DRB Application No.: <u>03-01735 (P&F)</u>	Project # <u>1003029</u>
Project Name: <u>EL RANCHO GRANDE</u>	EPC Application No.:
Agent: <u>Aldrich Land Surveying Inc.</u>	Phone No.: <u>884-1996</u>

5. **Project # 1003029**
03DRB-01734 Major-Bulk Land Variance
03DRB-01735 Minor-Prelim&Final Plat Approval

ALDRICH LAND SURVEYING, INC. agent(s) for CURB, INC. request(s) the above action(s) for all or a portion of Tract(s) 14, 15 & 16, **EL RANCHO GRANDE SUBDIVISION**, and Tract(s) A-2, ROSNER TRACT, Tract(s) 4-A, SALAZAR-DAVIS TRACTS AND TRACTS 32H-1-A, 33C-1-B & 4-A-1, LANDS OF CURB INC., zoned R-LT, located on GIBSON BLVD SW, between MESSINA DR SW and 98TH ST SW containing approximately 62 acre(s). [REF: 1002516, 03DRB-00331, 03DRB-00332, 1001594, 02DRB-01621, 02DRB-01622, 02DRB-01623] (N-8/N-9)

BULK LAND PLAT FOR
 TRACTS 14, 15 AND 16
 EL RANCHO GRANDE
 WITHIN THE
 TOWN OF ATRISCO GRANT
 PROJECTED SECTIONS 4 & 5
 TOWNSHIP 9 NORTH, RANGE 2 EAST, NMPM
 CITY OF ALBUQUERQUE
 BERNALILLO COUNTY, NEW MEXICO
 OCTOBER, 2003

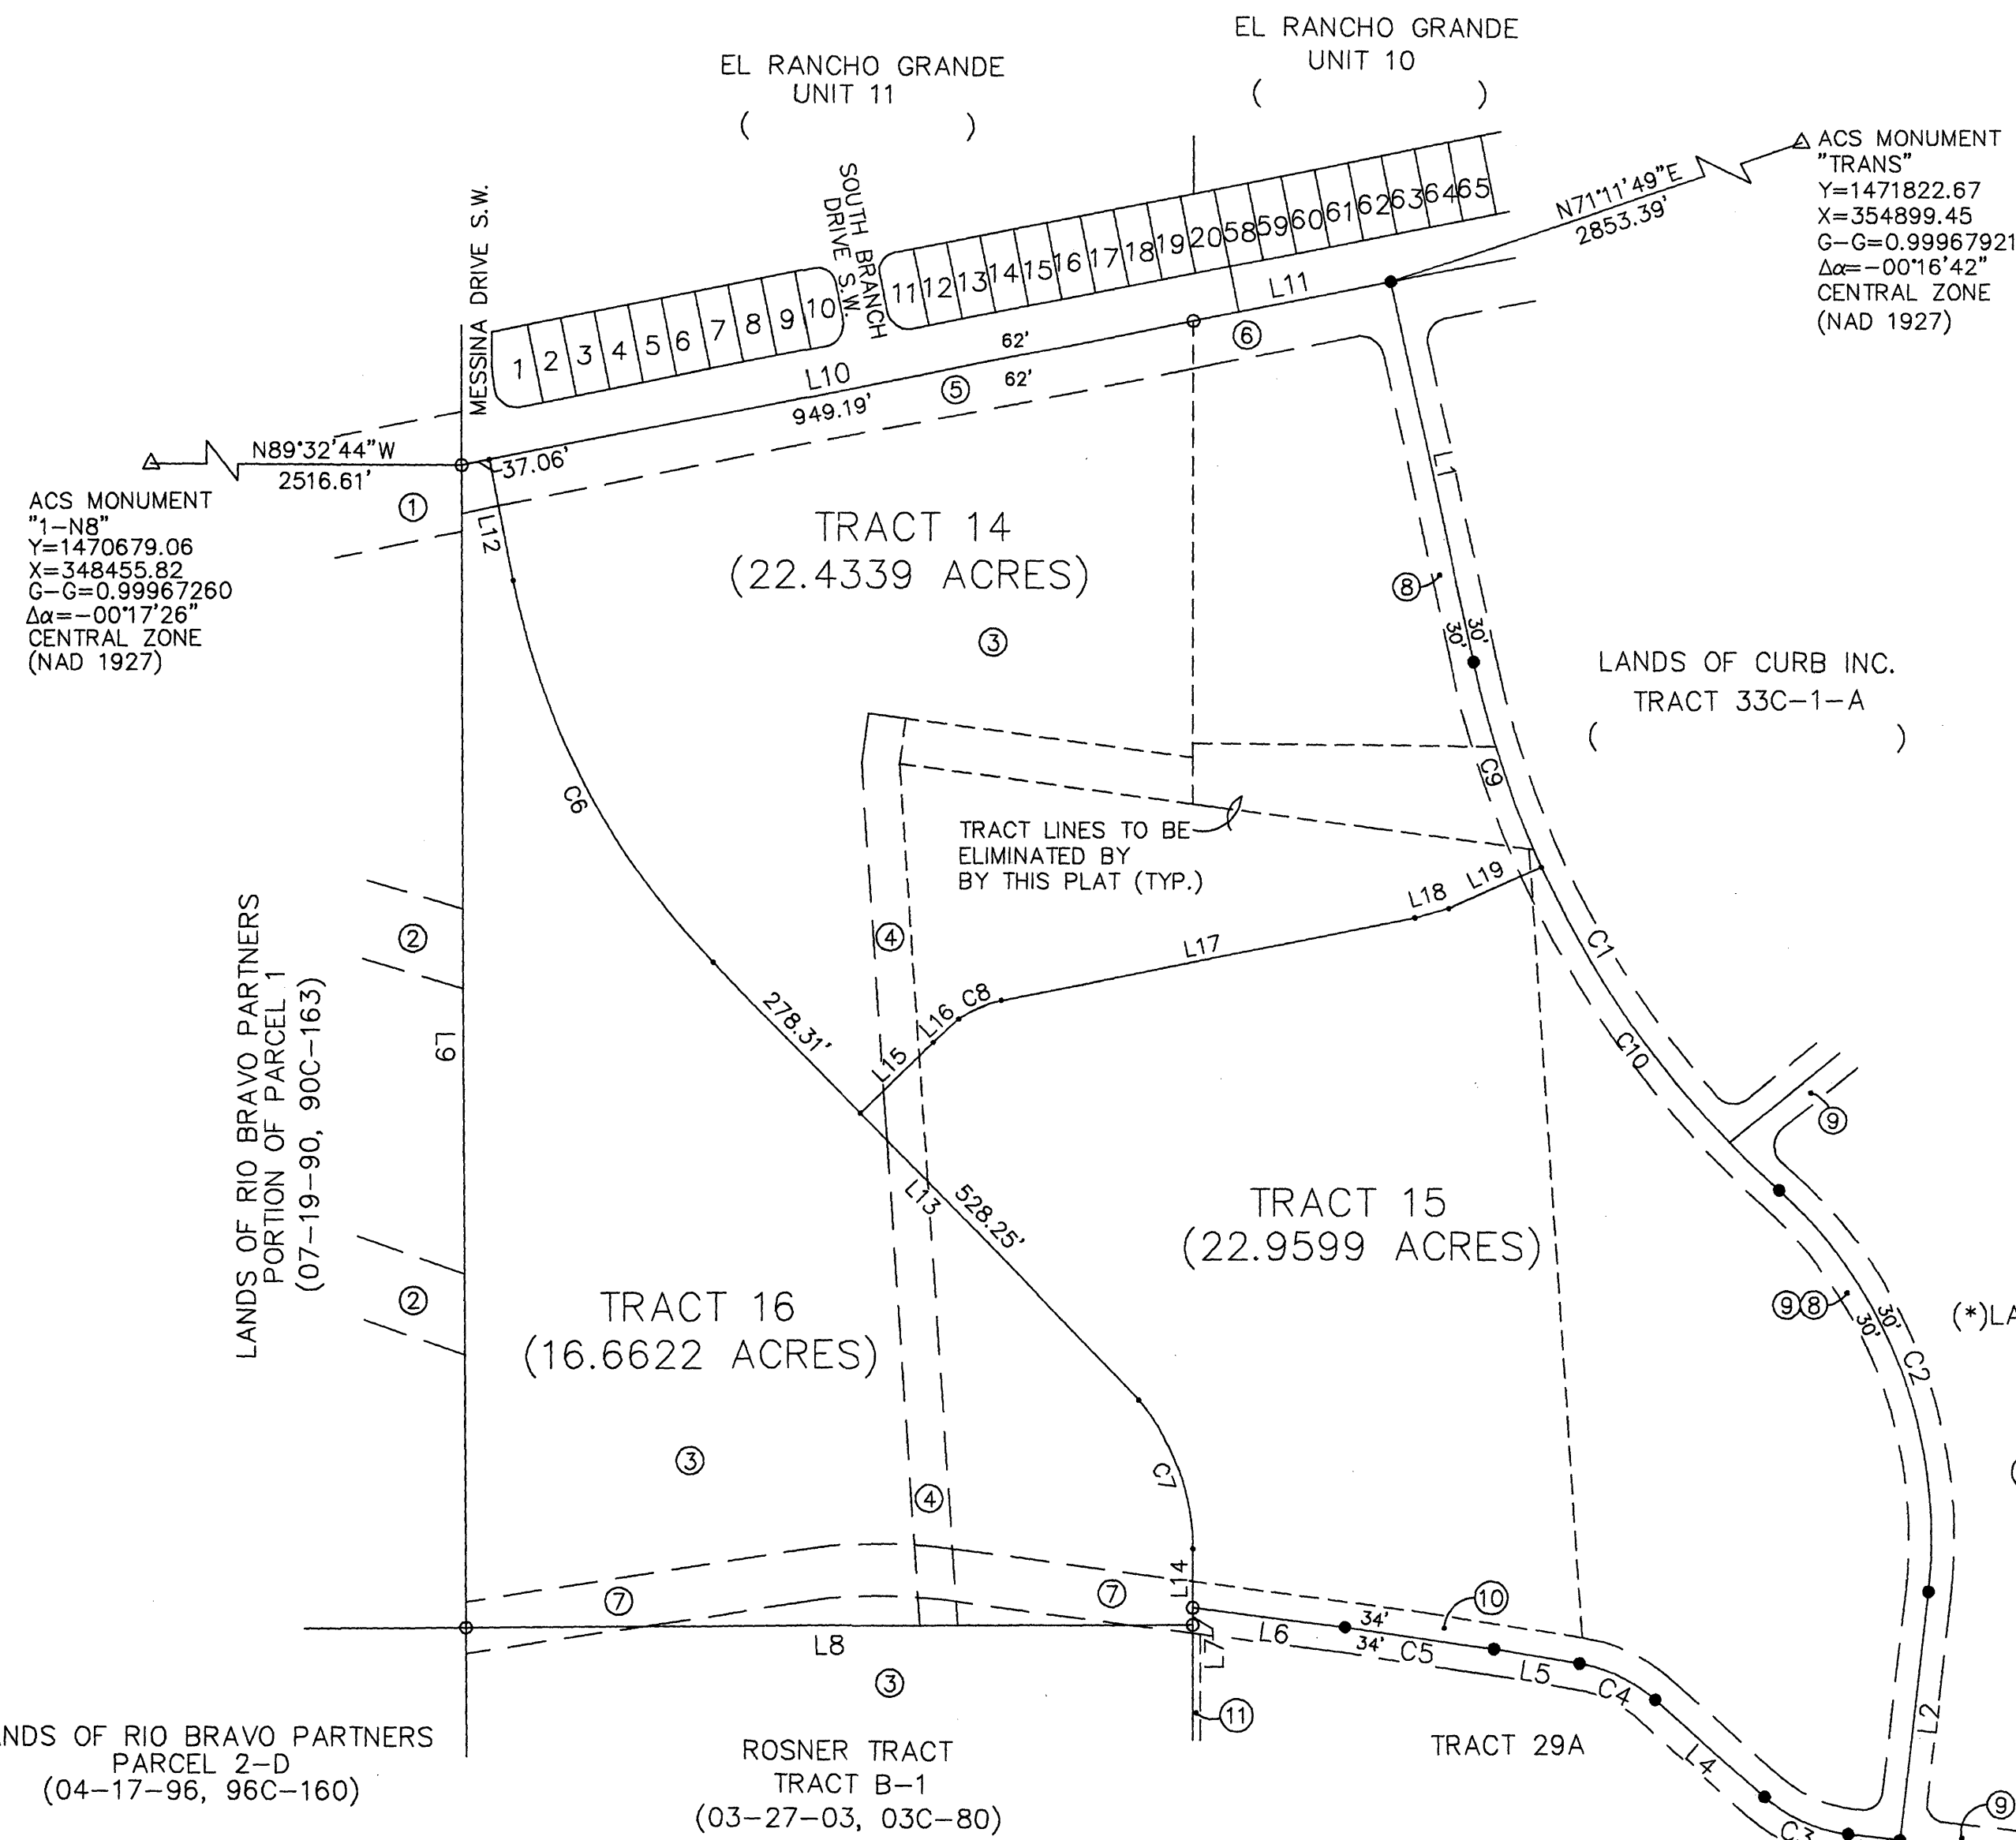
Has northern ½ of Gibson been dedicated?
